City of Albuquerque
Planning Department
Development Review Division
P.O. Box 1293
Albuquerque, New Mexico 87103

OFFICIAL NOTIFICATION OF DECISION

FILE: Project # 1005482*
07EPC-00430 EPC Site Development Plan-
Building Permit

LEGAL DESCRIPTION: for all or a portion of Tracts 2 & 3, Mira Mesa Estates, zoned C-2 (SC), located on HANOVER NW, between 64TH ST. NW and 68TH ST. NW, containing approximately 5 acres. (J-10) Anna DiMambro, Staff Planner

SHEET TITLE
L100
SHEET ___ OF ___

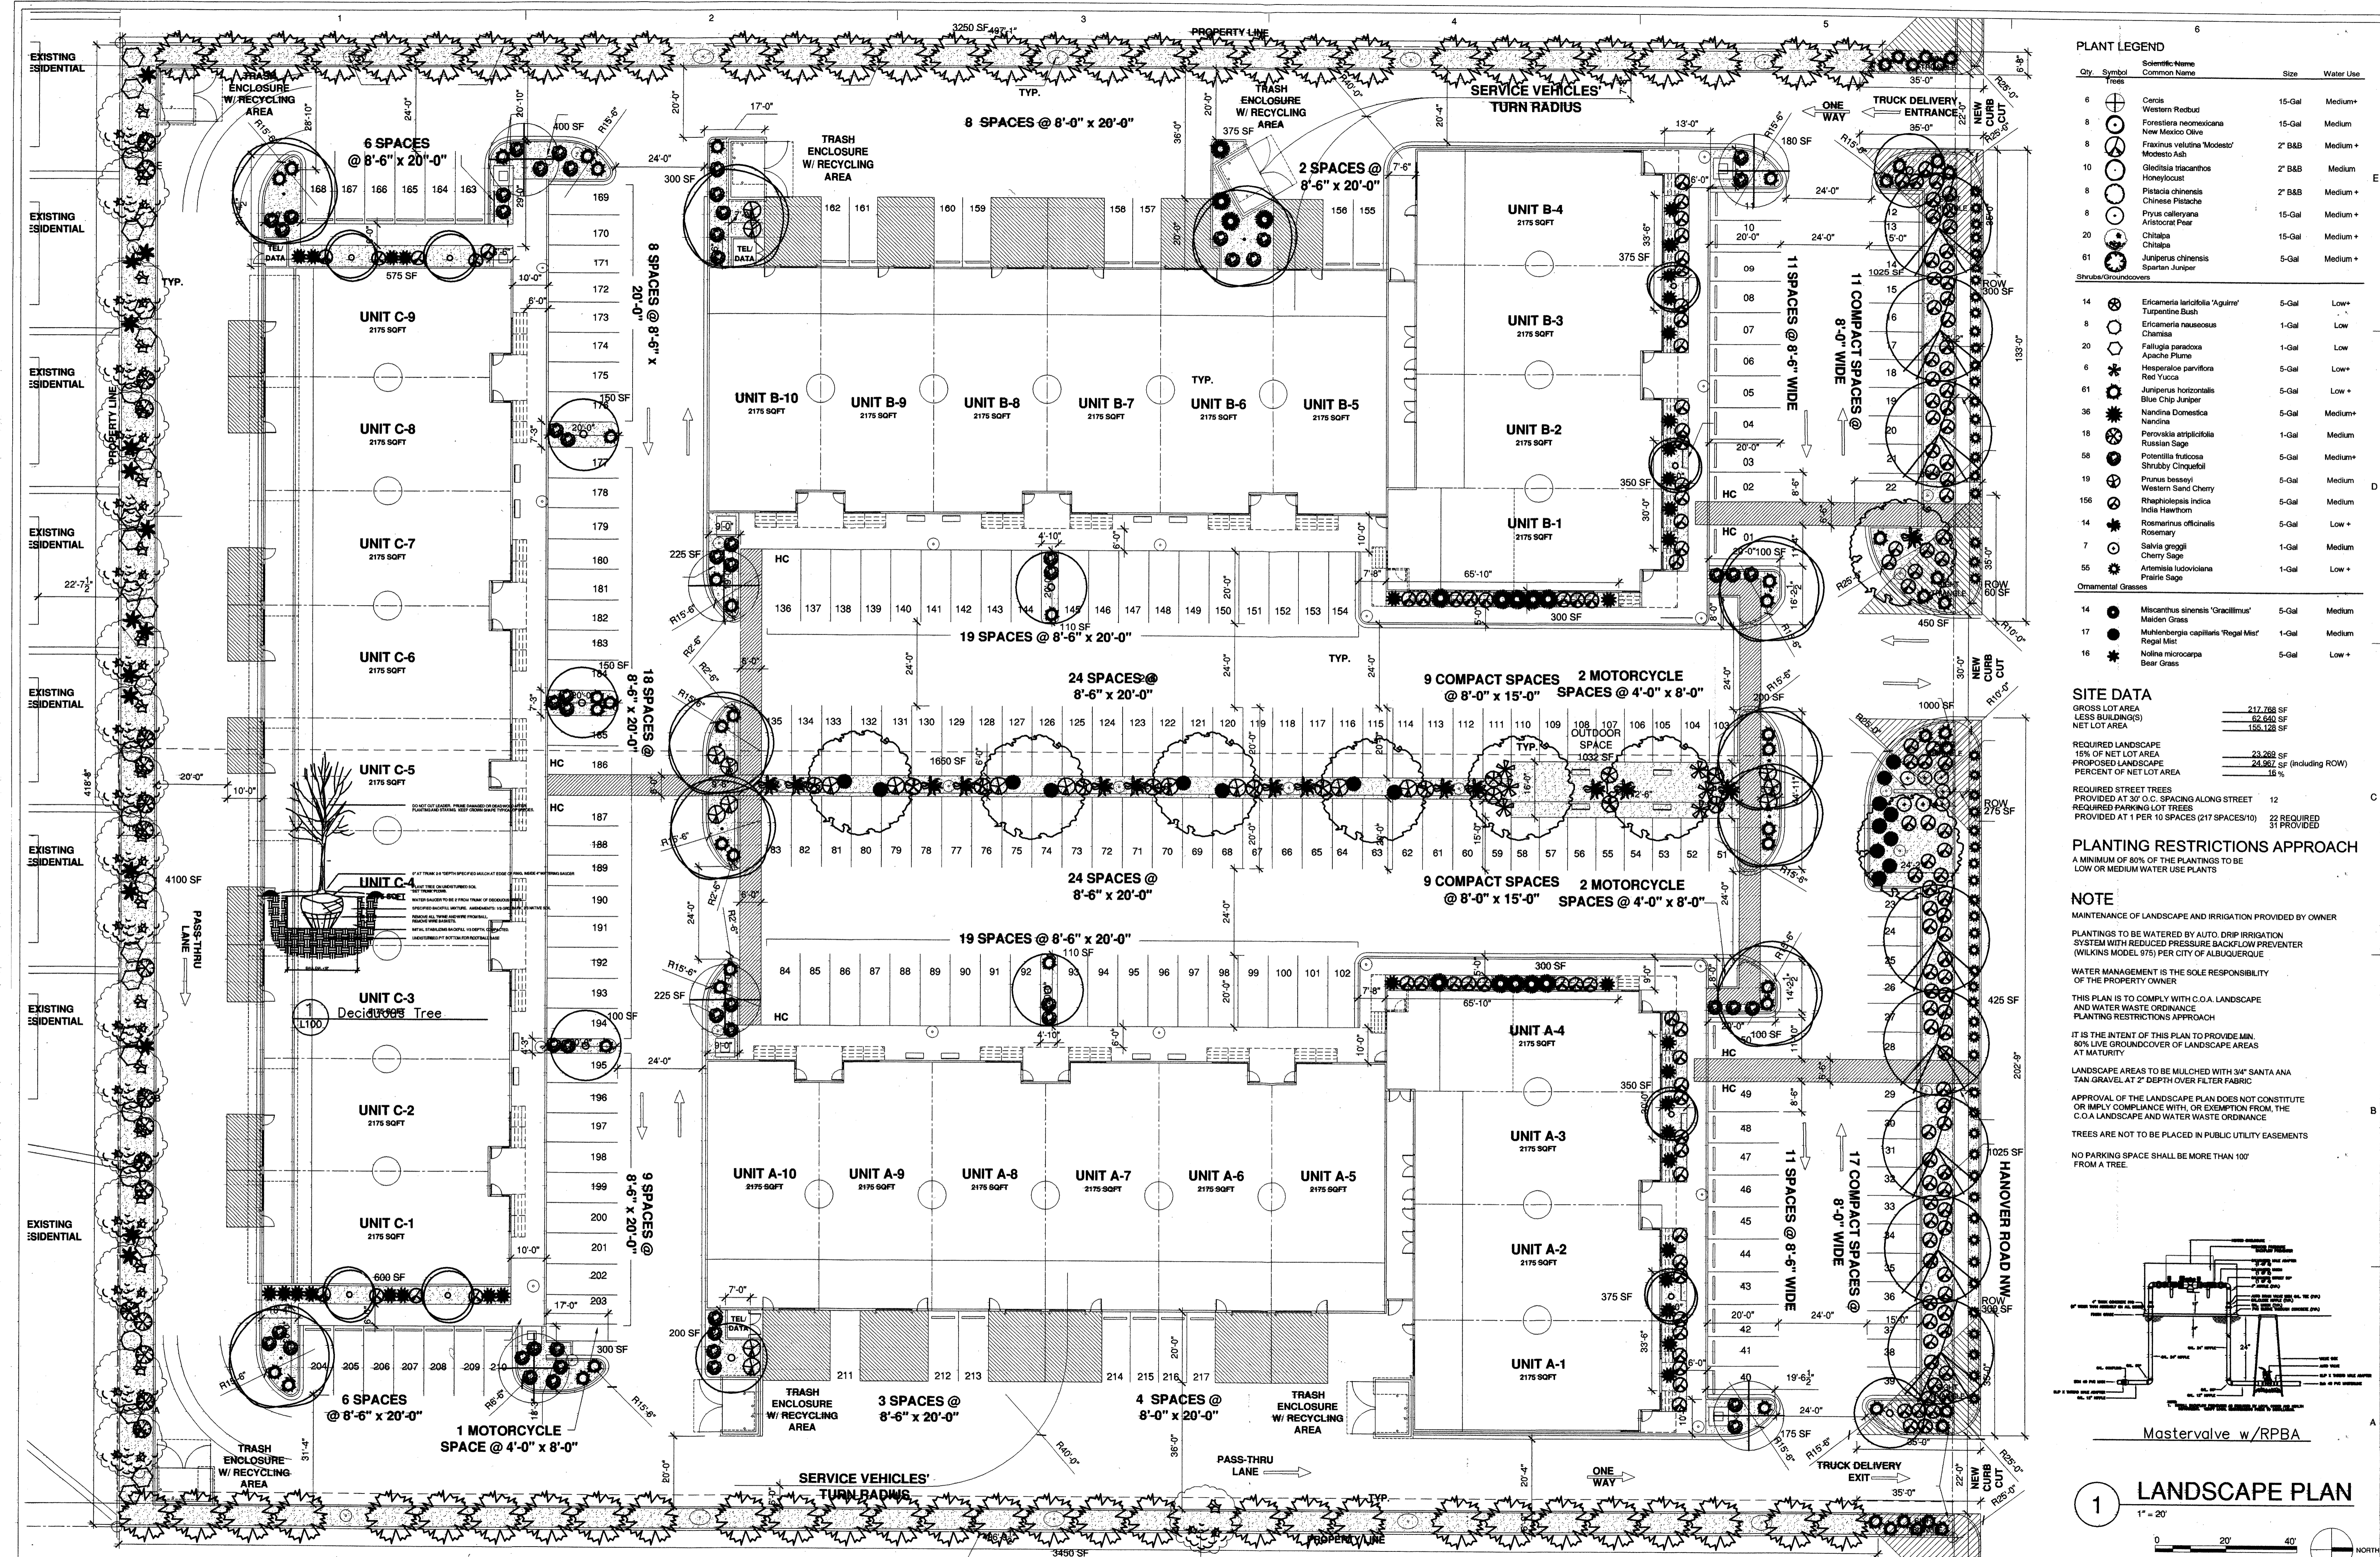
14. Typographical errors:
 - a. Hanover shall be spelled correctly and consistently on all sheets. MW shall be replaced with NW on pages C100 and C101.
 - b. Use proper form of the word "than" in the last Note on page L100.

- c. The number of parking spaces provided shall be revised on page L100.
 - d. Correct Proposed Conditions narrative on page C100. Replace "The natural lying along..." with "The natural low-lying area along..."

DESIGN VEHICLE RADIUS PLAN
C100
SHEET ___ OF ___

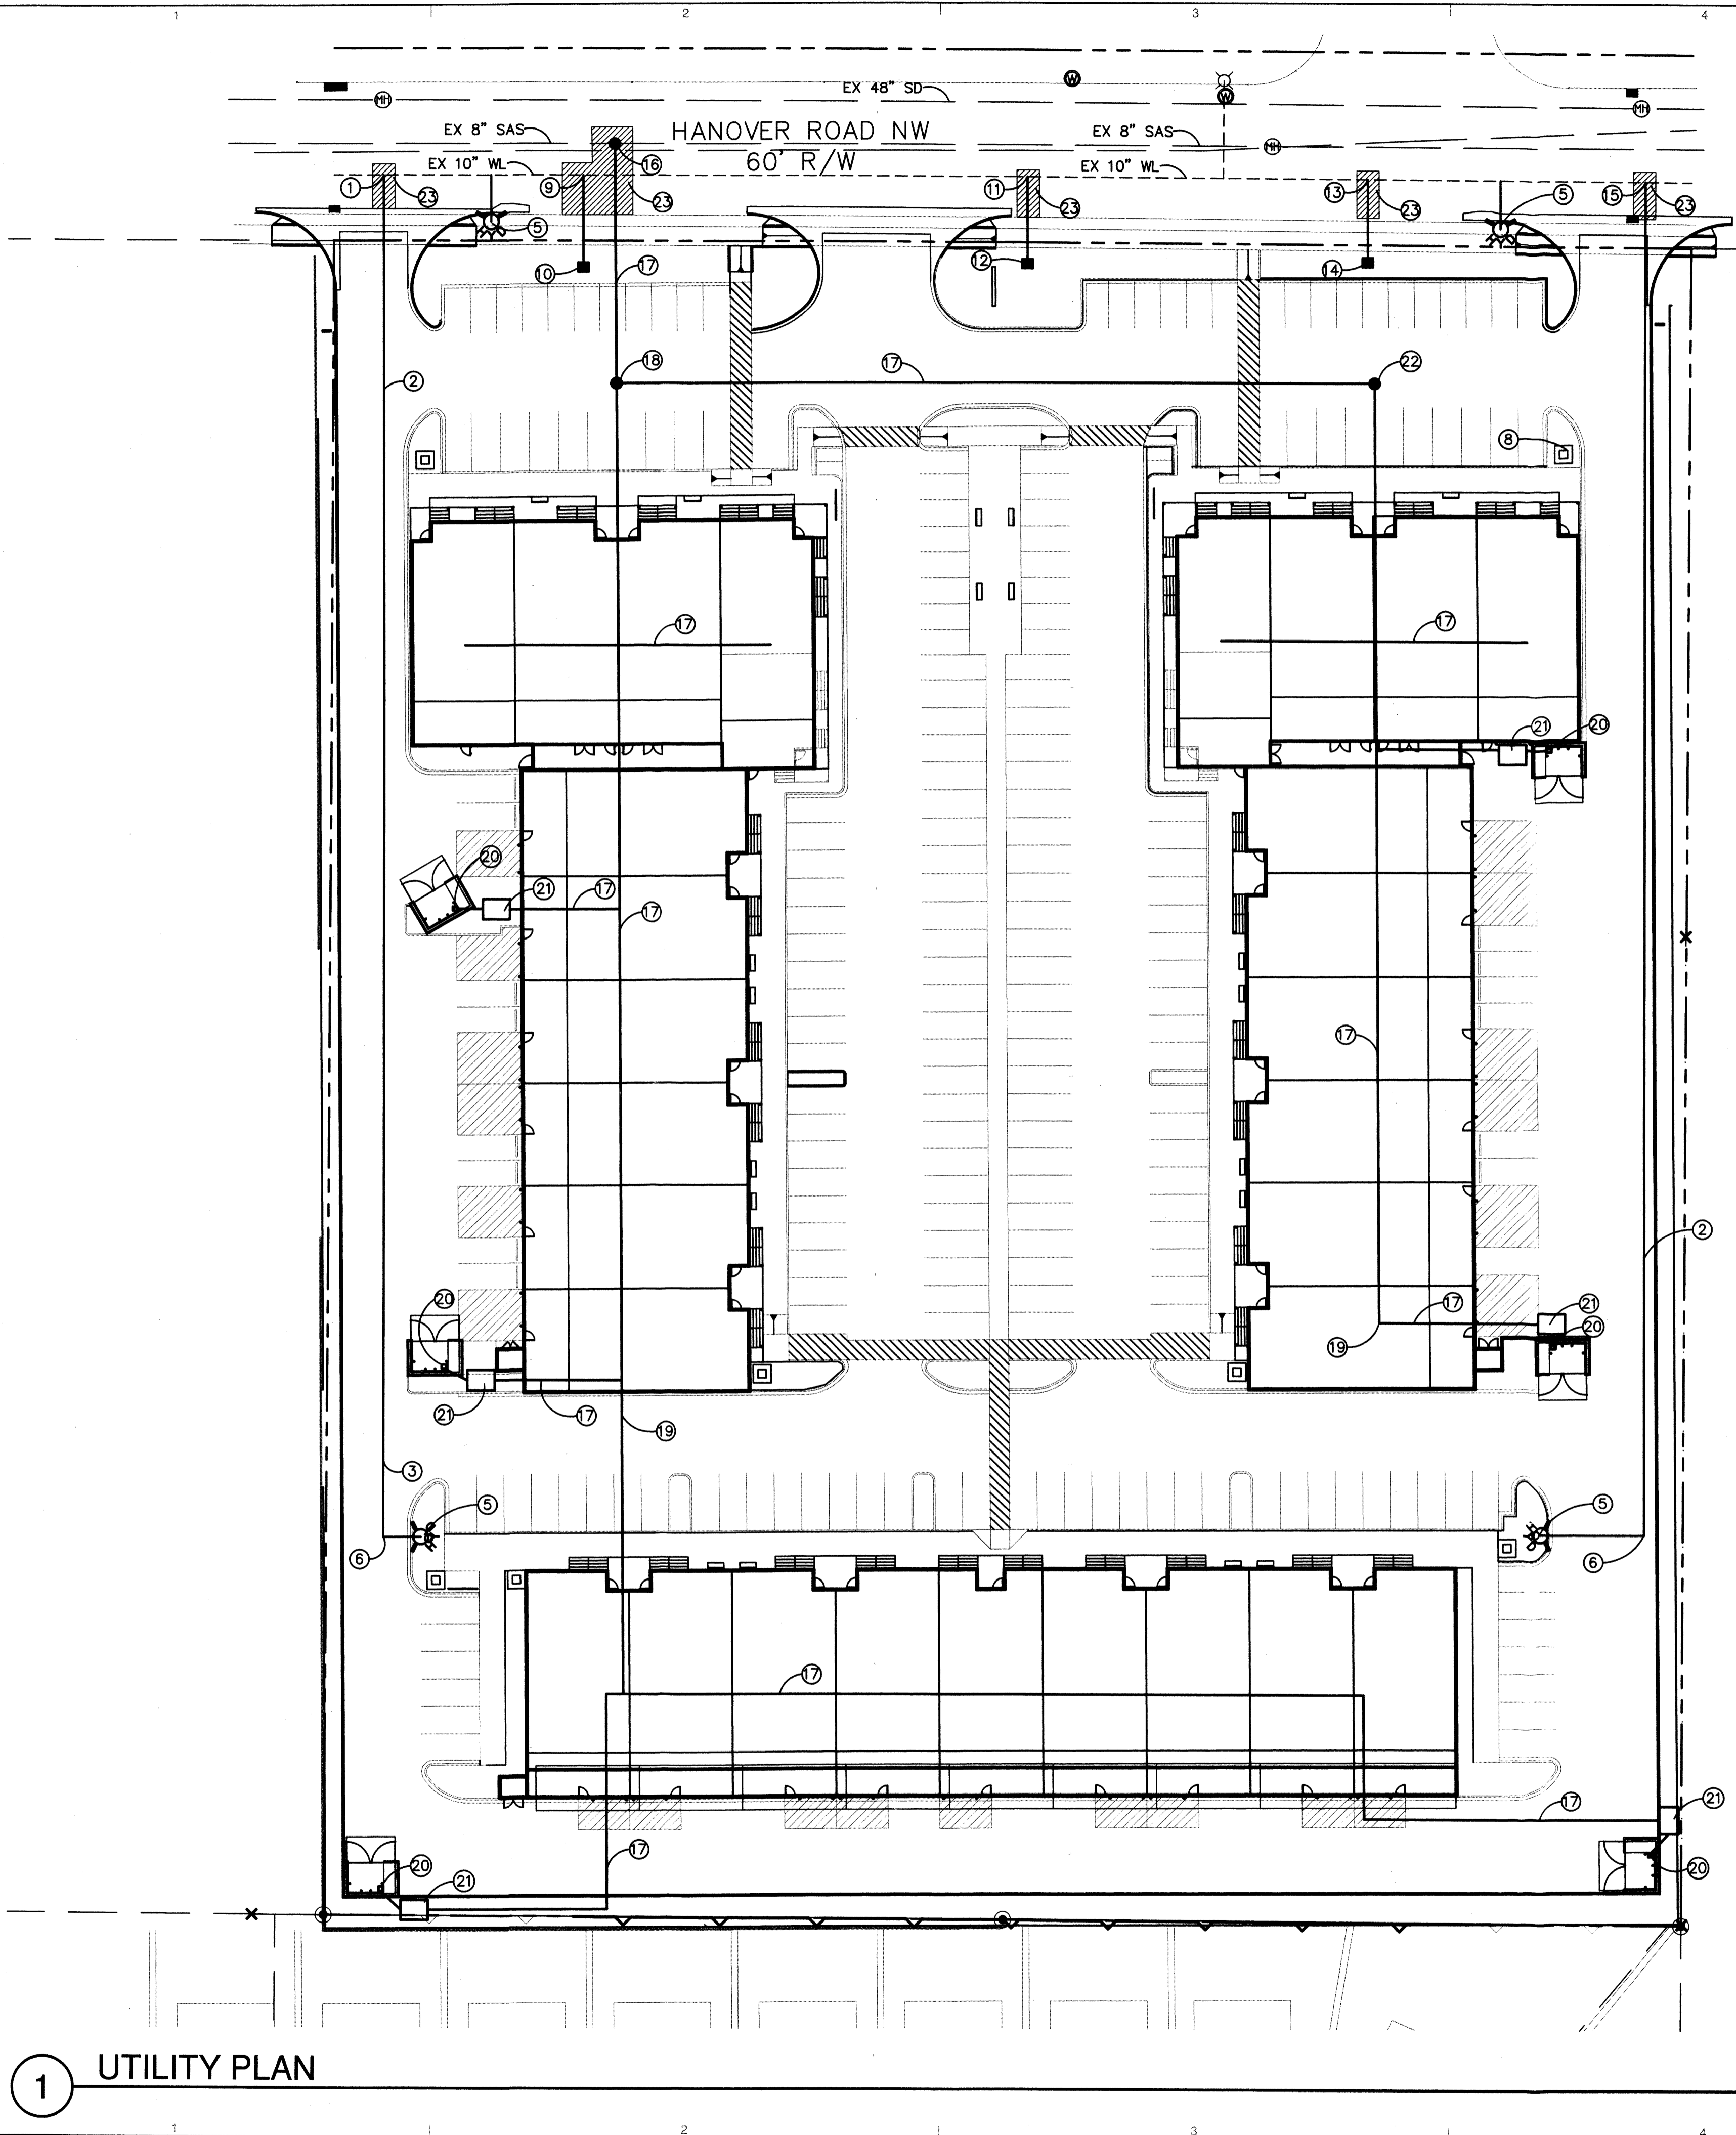
- e. Incorporate Tract 3 into narrative on page C100.
15. The applicant shall correct colors indicated on the site development plan to match those indicated in color renderings.
